Application no: H07/0753/97

Applicant: Mr & Mrs R Frisby
'Ennie'
Main Road
Parson Drove
Wisbech Cambs PE13 4LA
Description: Erection of new house

Amendment: Set dwelling back 3 metres (Drawing No. 004 Rev B)

TOWN AND COUNTRY PLANNING ACT 1990
NOTICE OF ACCEPTANCE OF AMENDMENT

Drawing:
SITE AND LOCATION PLANS

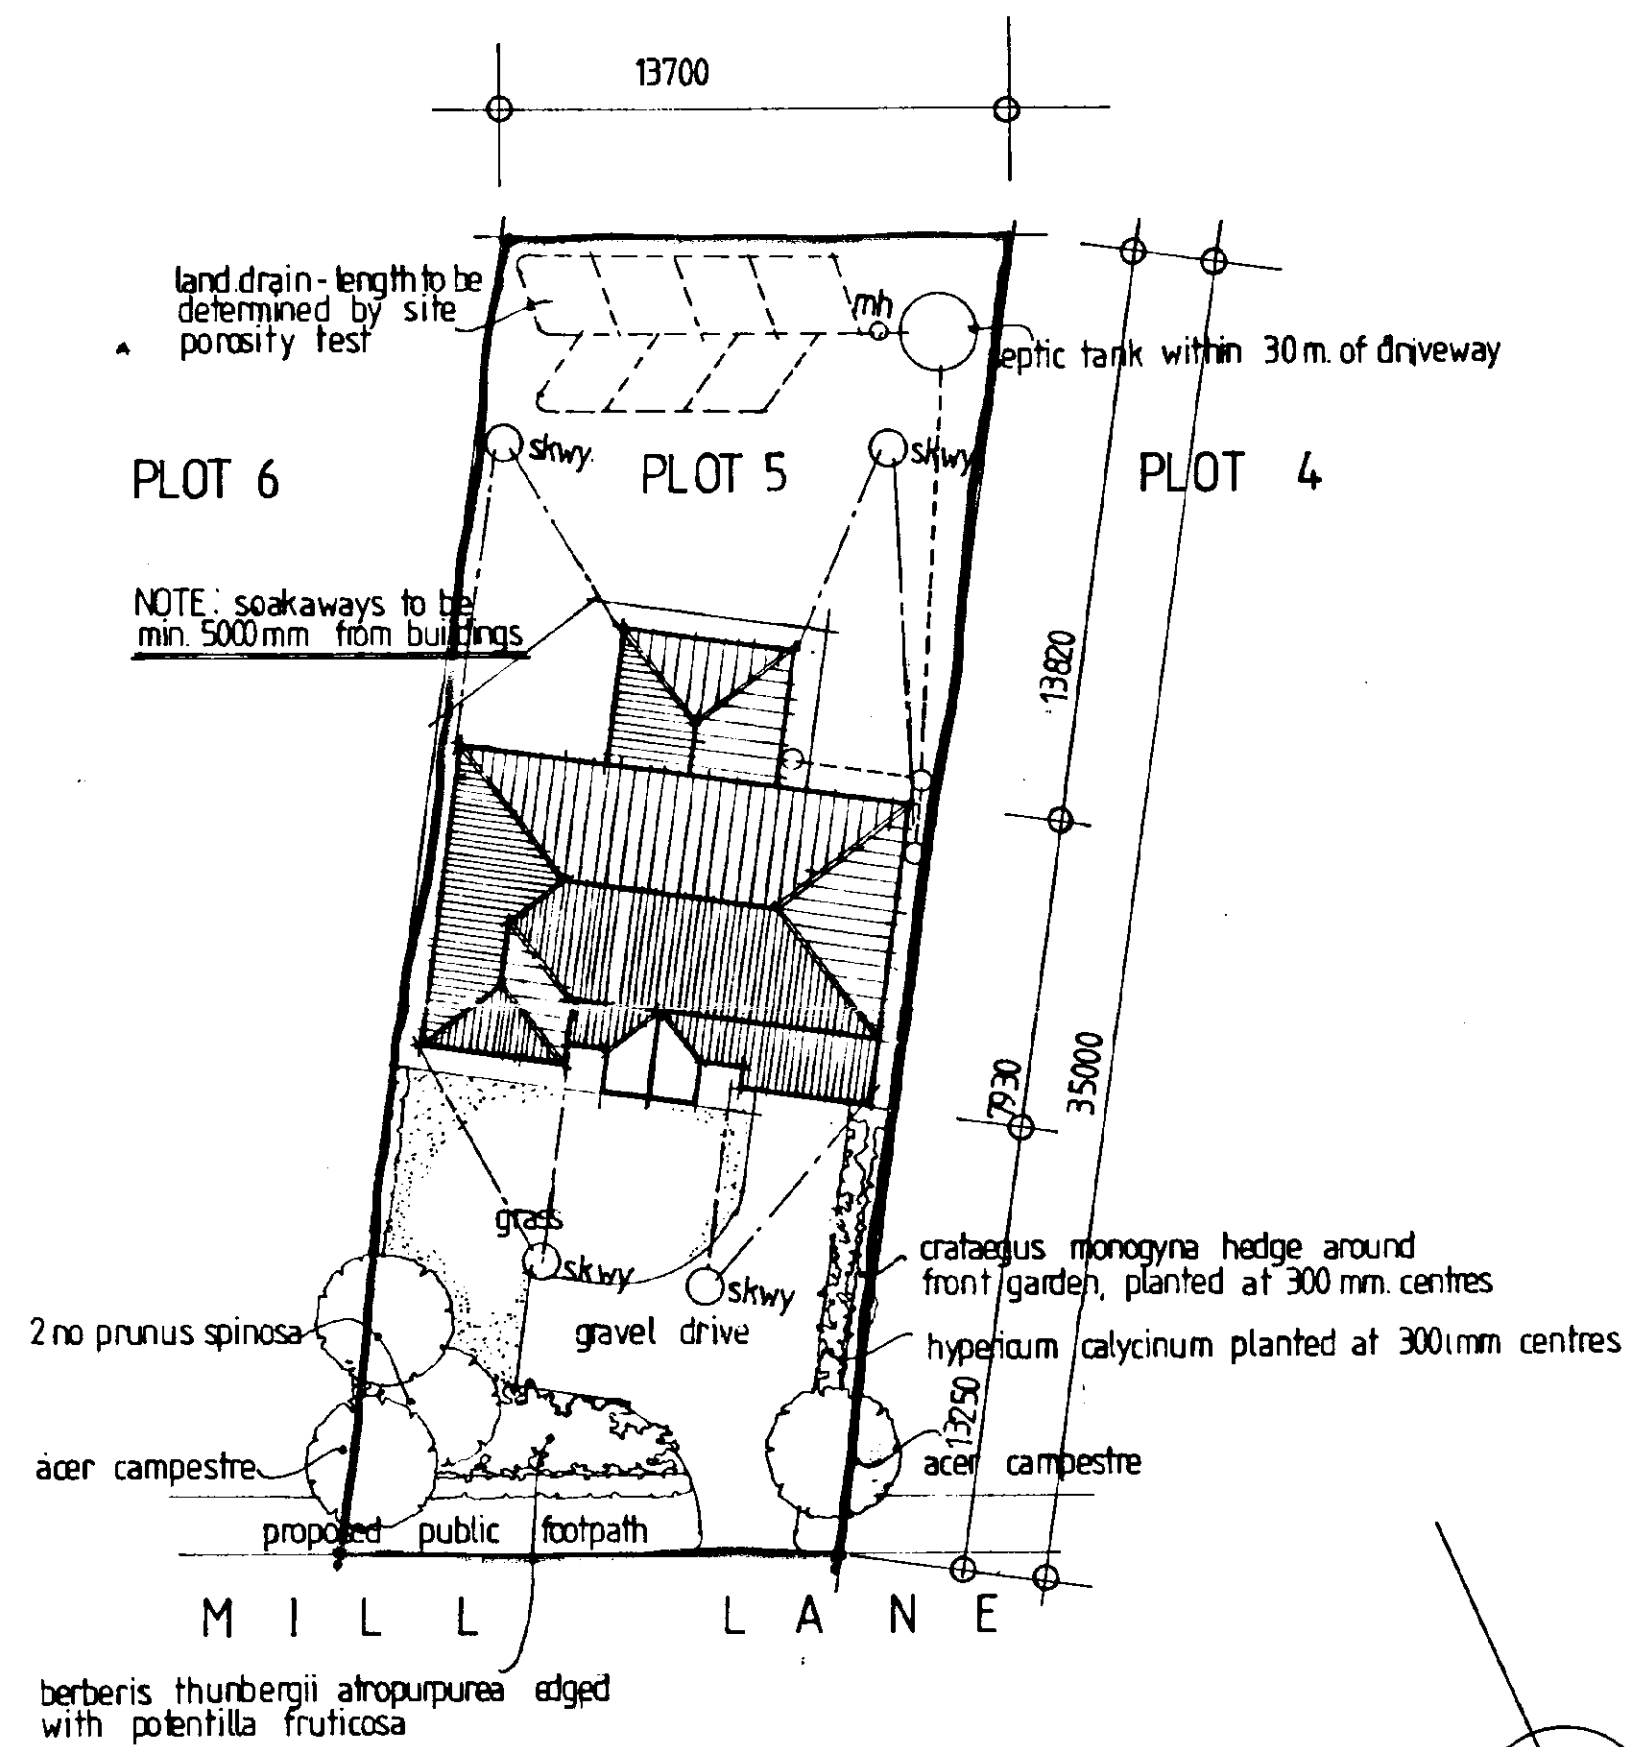
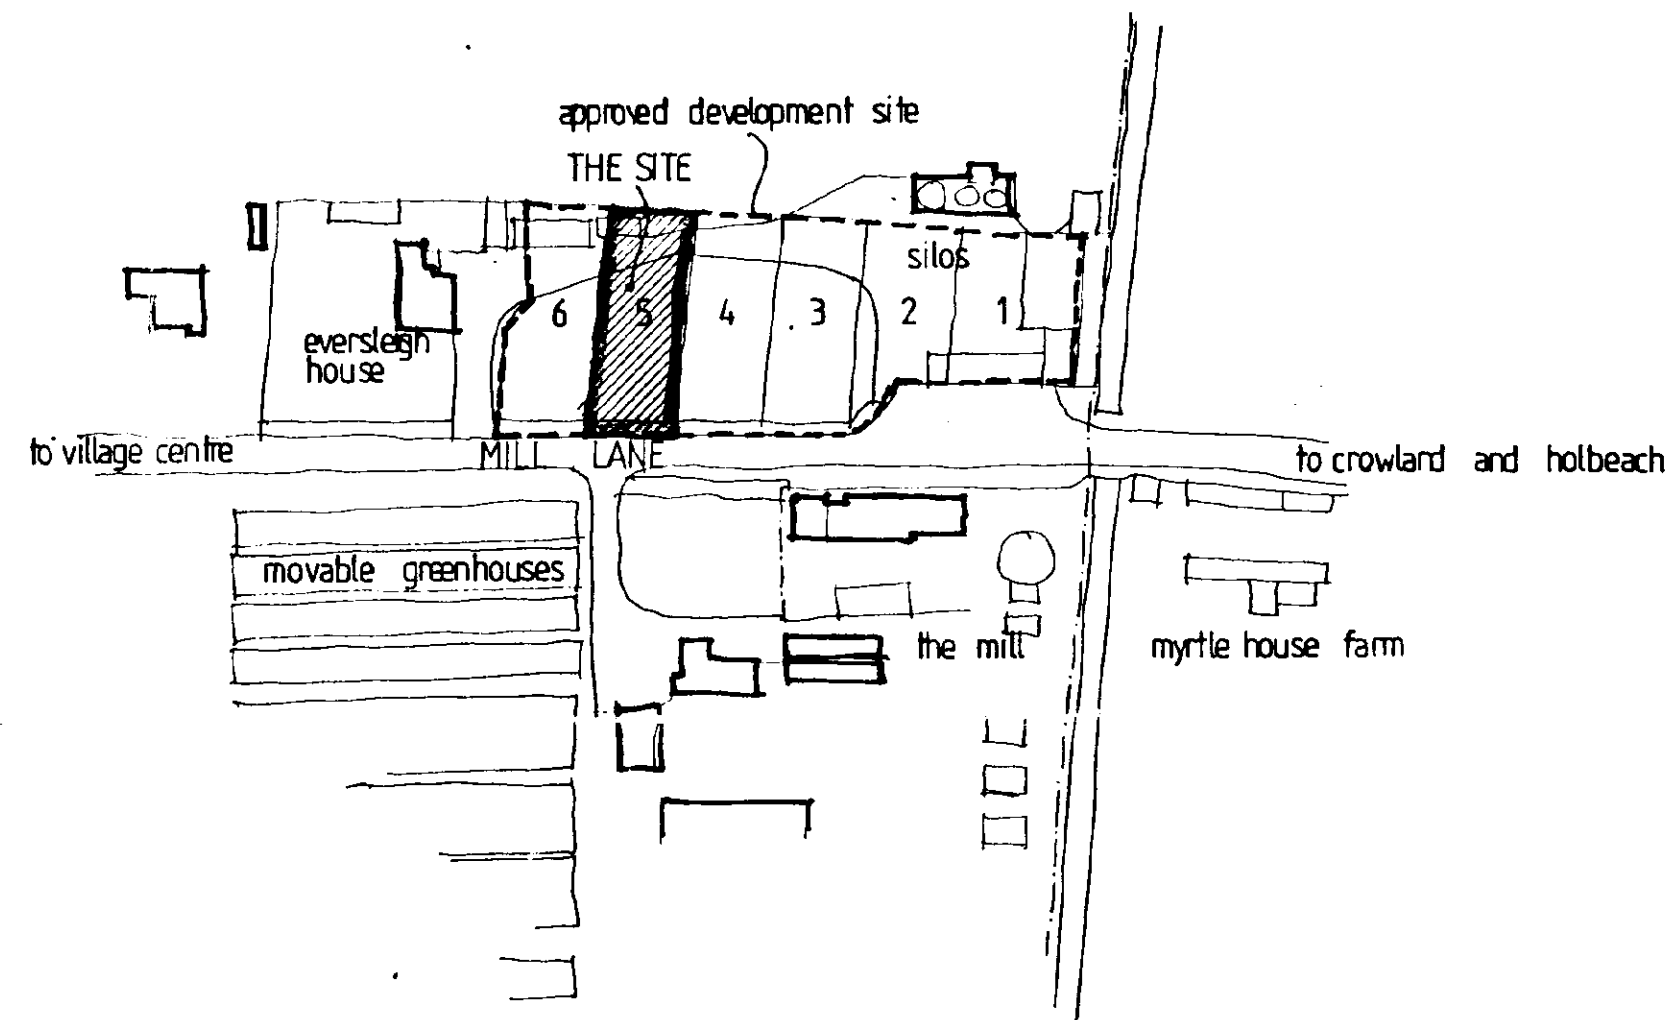
Set Dwelling
back 3mts.
